AGENDA ITEM: DFT Project Number: PR-2023-008423

Application Number: SI-2023-00606 Project Name: 4821 Pan American West – Lexus

#### CODE ENFORCEMENT COMMENTS & APPLICANT RESPONSES

Comments from: Jeff Palmer, Code Enforcement Supervisor DATE: 4/5/23

SHEET DESCRIPTION: SITE PLAN

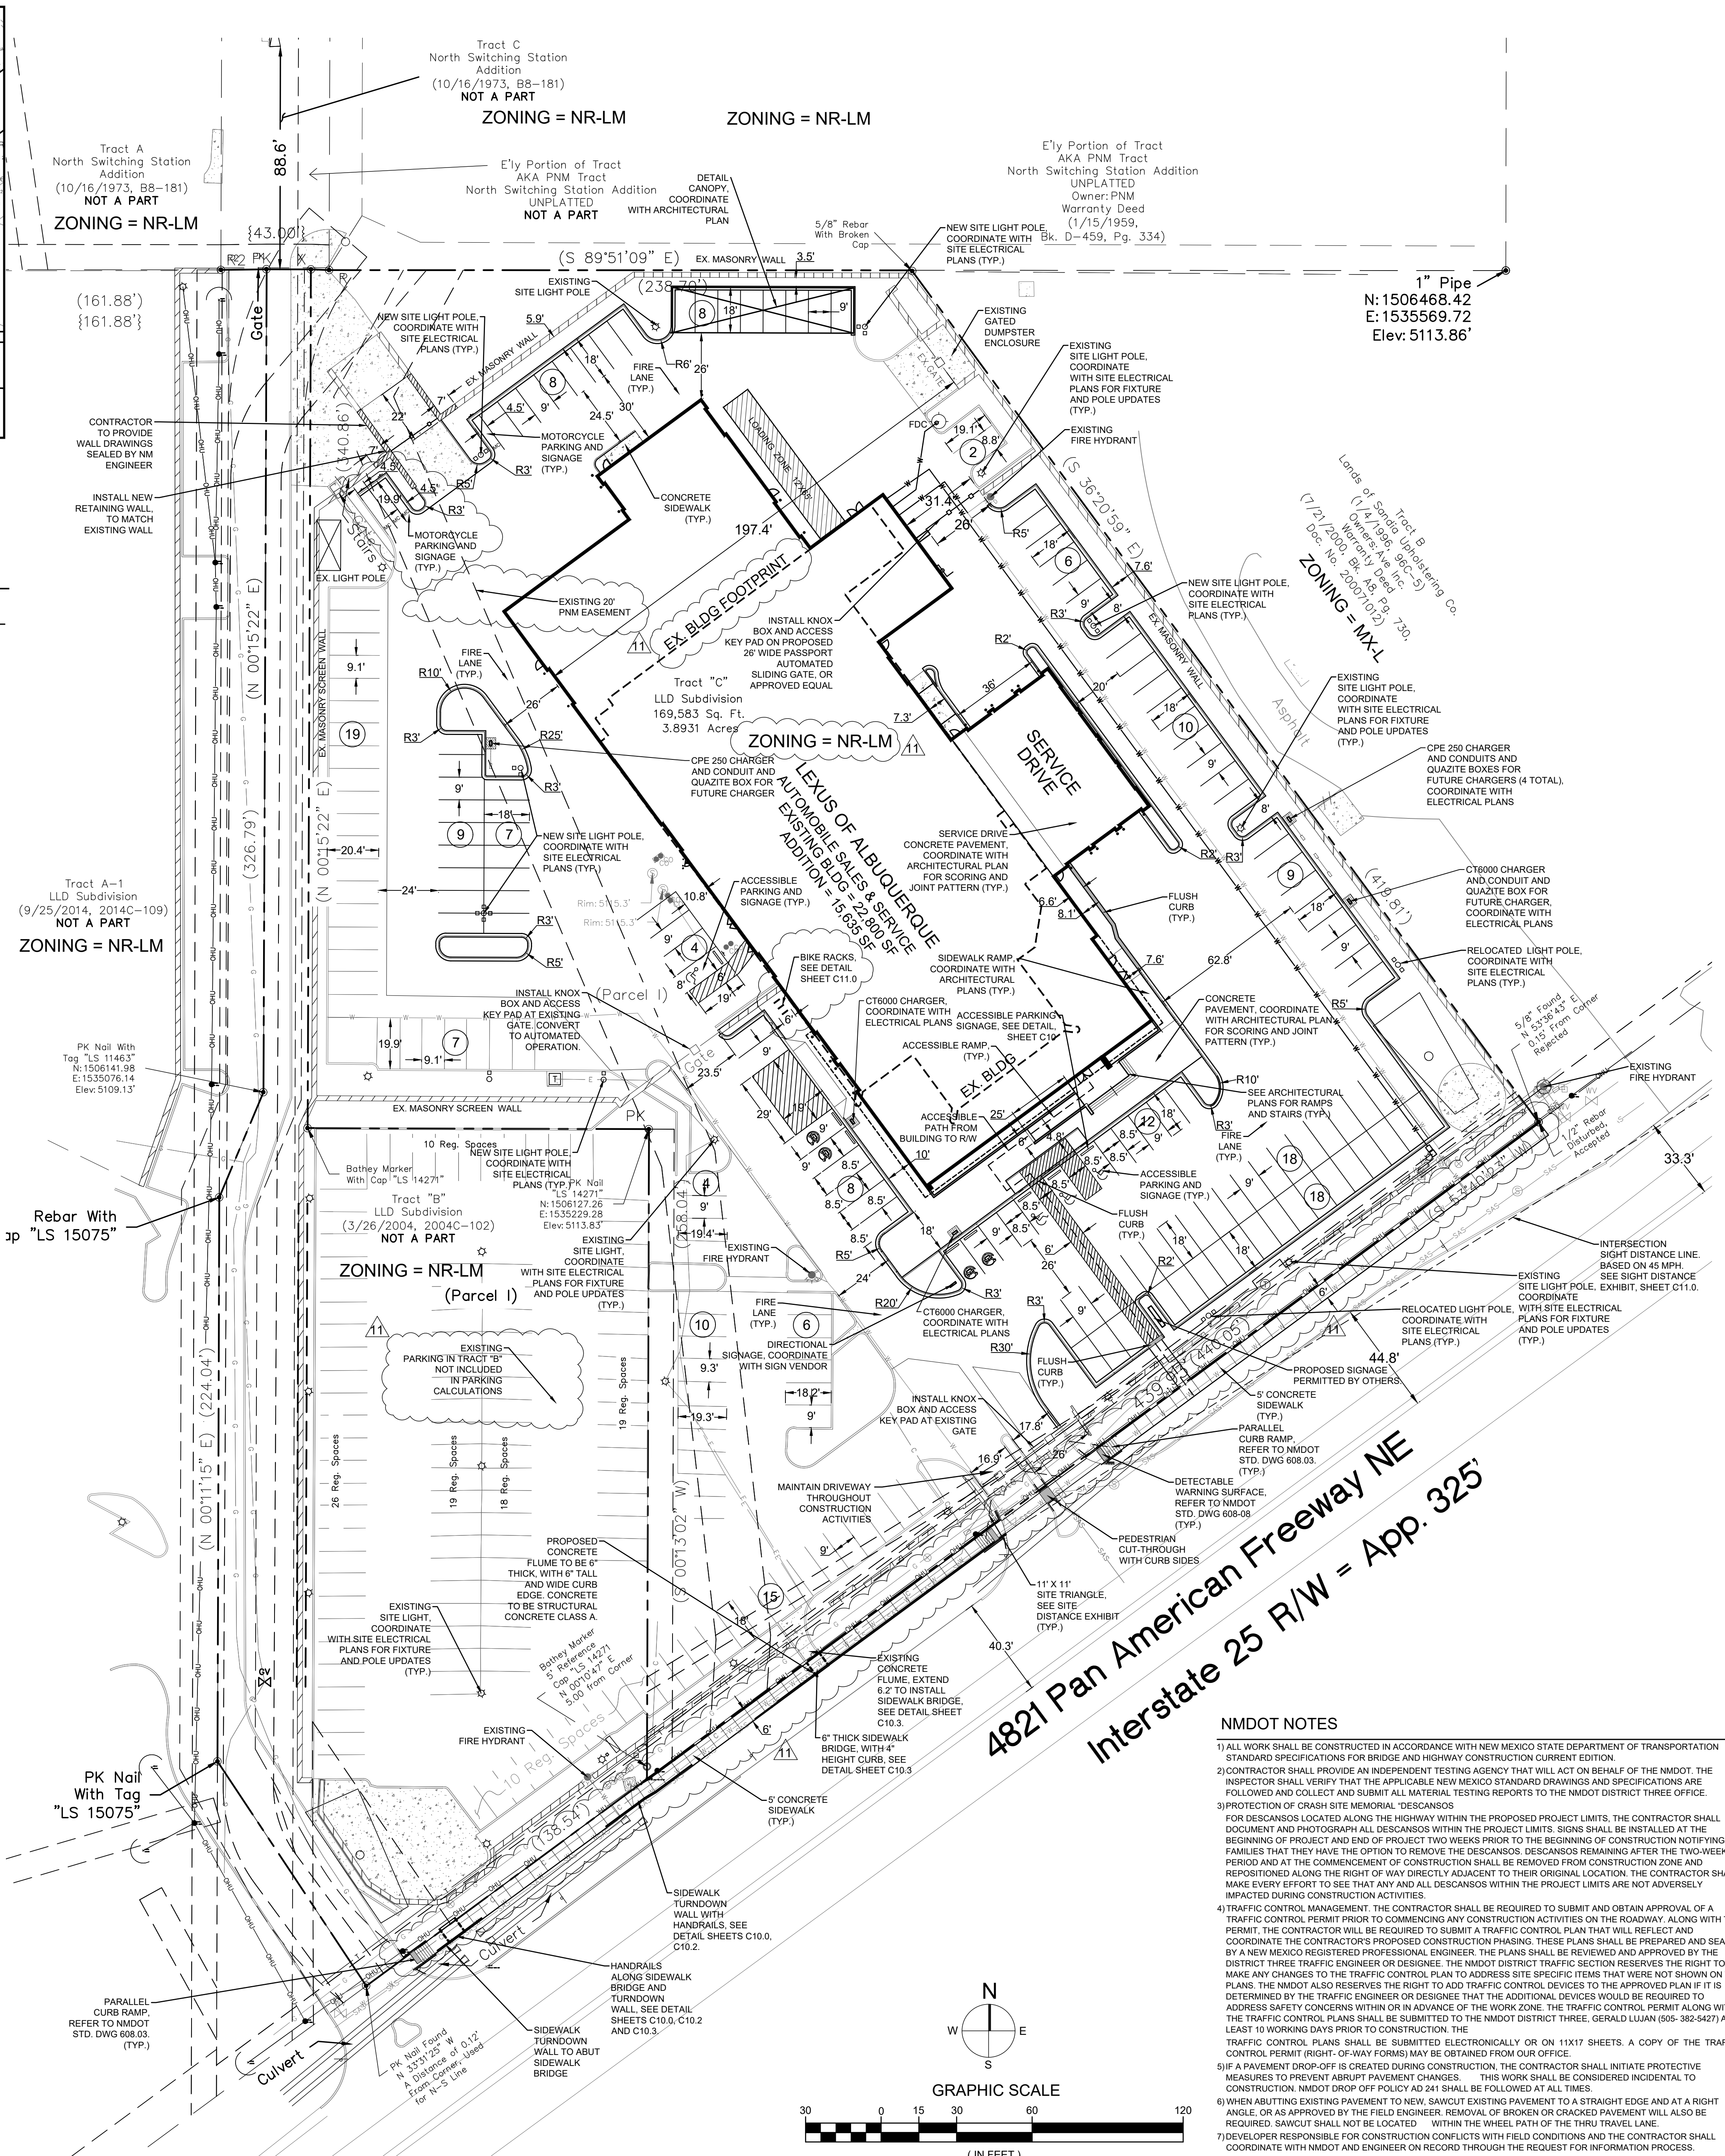
3. Motorcycle parking requires 3 spaces for 52 required off-street, per Table 5-5-4: two provided on plan.

4. Bicycle spaces require 5 spaces for 52 required off-street spaces, per Table 5-5-5: three provided on plan.

RESPONSE: Plan has been revised to provide 4 motorcycle parking spaces, which exceeds the required 3.

RESPONSE: Plan has been revised to provide 6 bicycle spaces, which exceeds the required 5.
